Appendix D Supplementary responses

COMMENTS REGISTER			
Project Name:		Panorama BESS	
Client Project Manager:		Christopher Smith	
SLR Project No:		660.v30234.00003	
SLR Project Manager:		Charlie Seventekin	
Revision:		v1.0	
Revision Date:		Wednesday, 16 April 2025

The right turn onto Masters Rd is very wide with multiple turning lanes. The transformer combination will have no issues making this turn with no modifications.

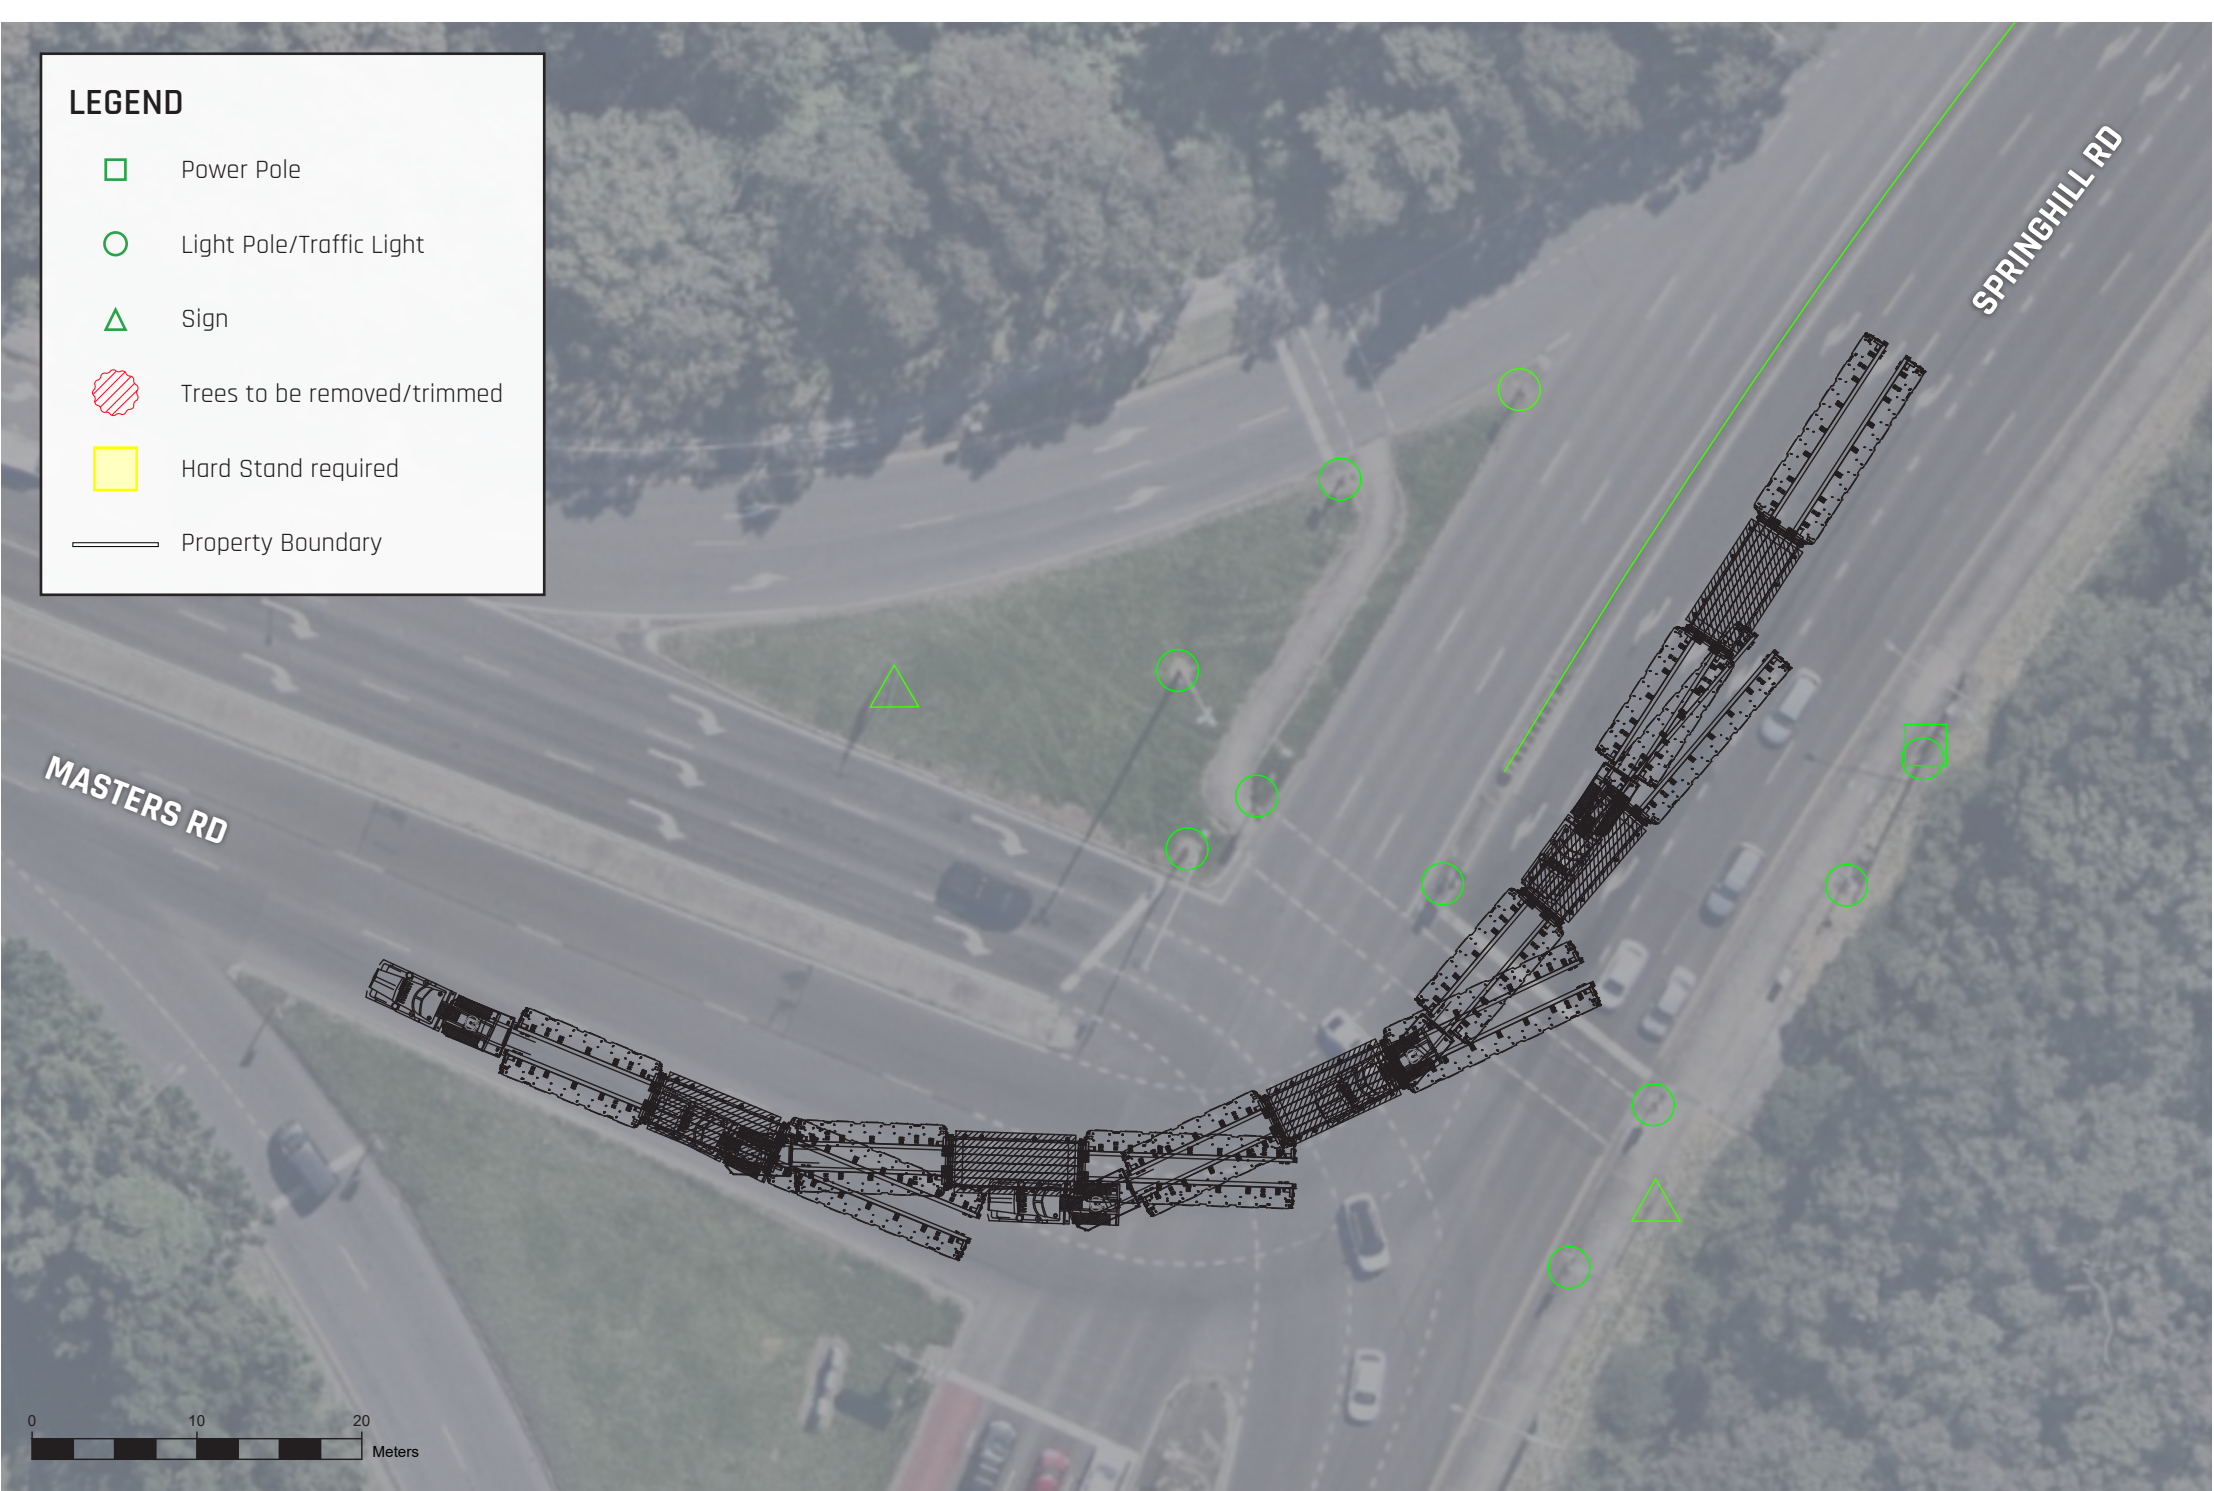
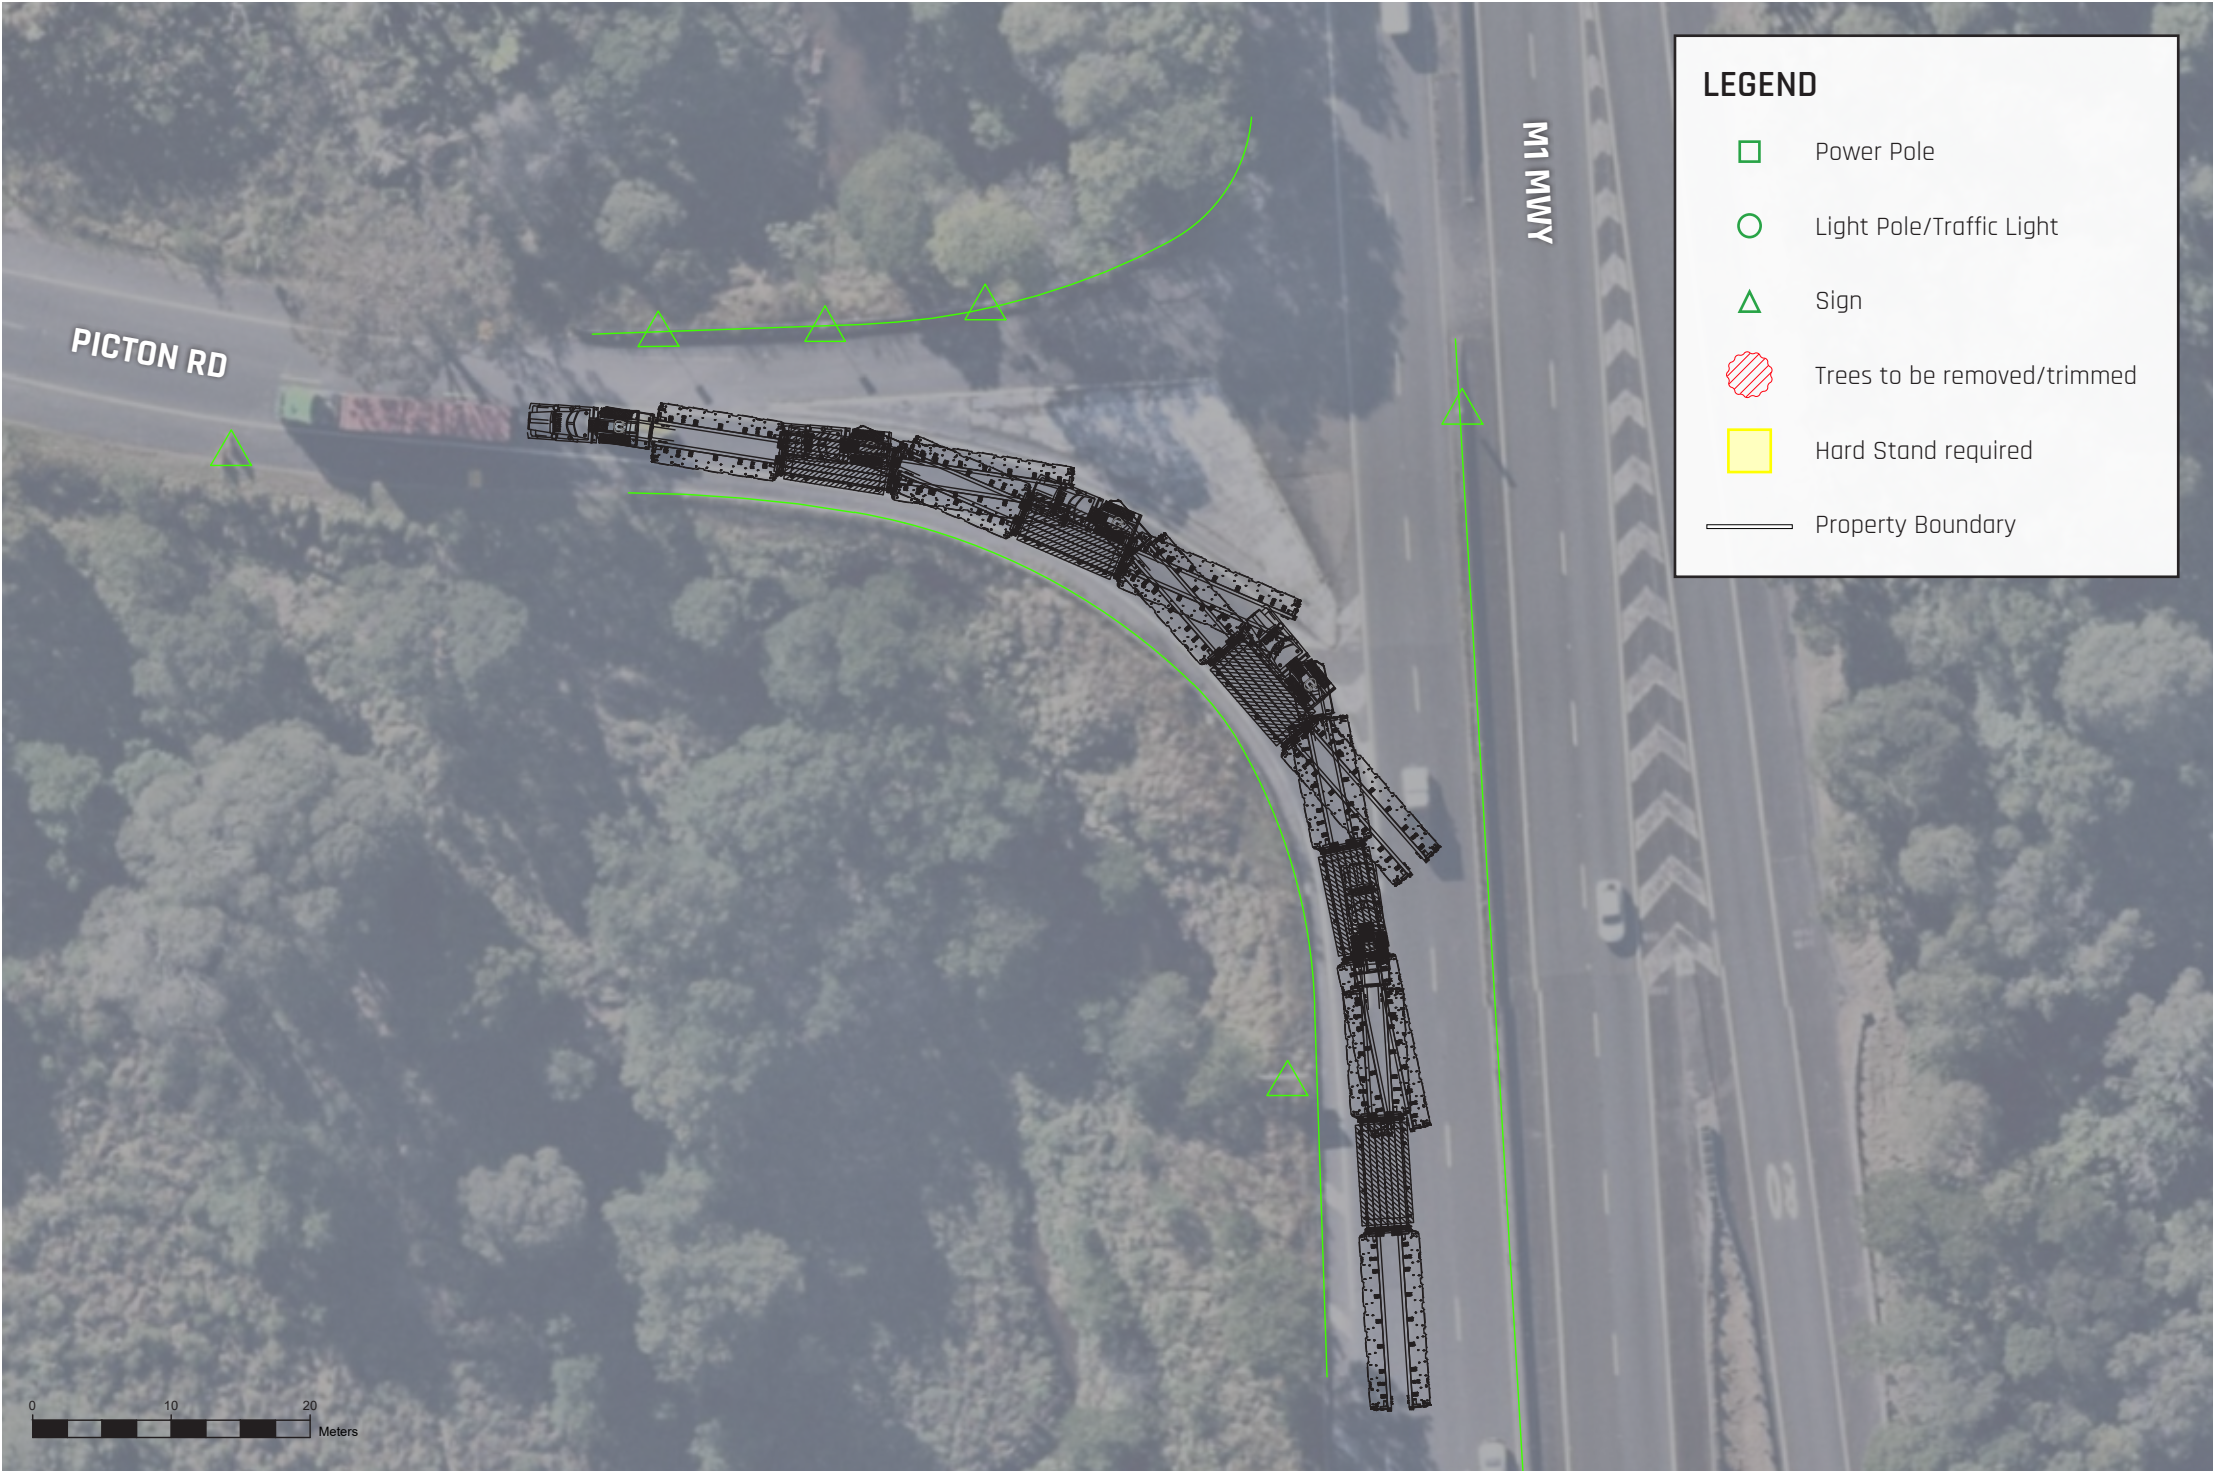
6	OSOM vehicle for the transformer is classified as high risk OSOM (as defined on TfNSW website in this link) due to its proposed height exceeding 5.20m. A Concept Level Route Analysis is required with the following information: • The route from port or point of origin to site access and intersections required to facilitate high risk OSOM movements required for the project. • Details of all high risk OSOM loads and vehicle configurations for the project. • Location of pull-over bays / rest areas along the high risk OSOM routes (including GPS coordinates) and demonstration swept paths of high risk OSOMs can be physically accommodated (in terms of size, width and accessibility). • Road geometry details and alignment along identified transport route(s), including existing formations, crossings, bridges, intersection treatments and any identified hazards, including: o Bridge Assessments for any at risk bridges on the classified road network due to dimensions and weight of OSOM vehicles. o Swept path analysis demonstrating the largest design vehicle can enter and exit the site and simultaneously pass through intersections along the proposed transport route(s). o Design vehicle templates used in the swept path analysis software in order for TfNSW to review performance (e.g. Autodesk Vehicle Tracking or Transoft AutoTURN). o Highlighting each at-risk road structures that haulage route(s) cross including bridges, traffic signals, signage, major culverts and minor culverts that may not meet desirable cover to cater for proposed axle loads. • Identify and provide the following measurement parameters of OSOM components / materials to be moved: o Types and numbers of high risk OSOM vehicles. o Overall combination type, configuration, load and vehicle configuration. o Wheelbase dimensions. o Length, width, height and mass (GCM, tare, weight to axle and payload) for components and nominated vehicles. o Maximum trailer articulation angle(s). o Minimum overhang heights above the road surface. o Vehicle configurations. o Traffic mitigation measures or road works, modifications or road upgrades to facilitate the movement of high risk OSOM(s). o Potential high level mitigation measures or commitments to mitigate known traffic, safety and impacts to road users along the high risk OSOM route(s) (i.e school bus routes, mining shift changes, TSRs, harvest periods and events). • Identify and assess implications of any road and rail projects that may be under construction during the indicative schedule for the OSOM movements. Note: NHVR permits do not cover road works or upgrades and environmental approvals required for proposed OSOM route(s). Any road works or upgrades works required along the OSOM route must be included within scope of works in the SSD to ensure constructability. Note: Given high number of renewable energy and other large scale projects requiring haulage of OSOM components on the road network, restrictions and limitations on OSOM movements may be imposed. In this regard, it is recommended you engage early with TfNSW's Development Services Renewables team to discuss the requirements of the route assessment.	ADDRESSED IN SECTION 2.5.4 and Appendix H.	Reference is made to TfNSW request in Section 2.5.4.
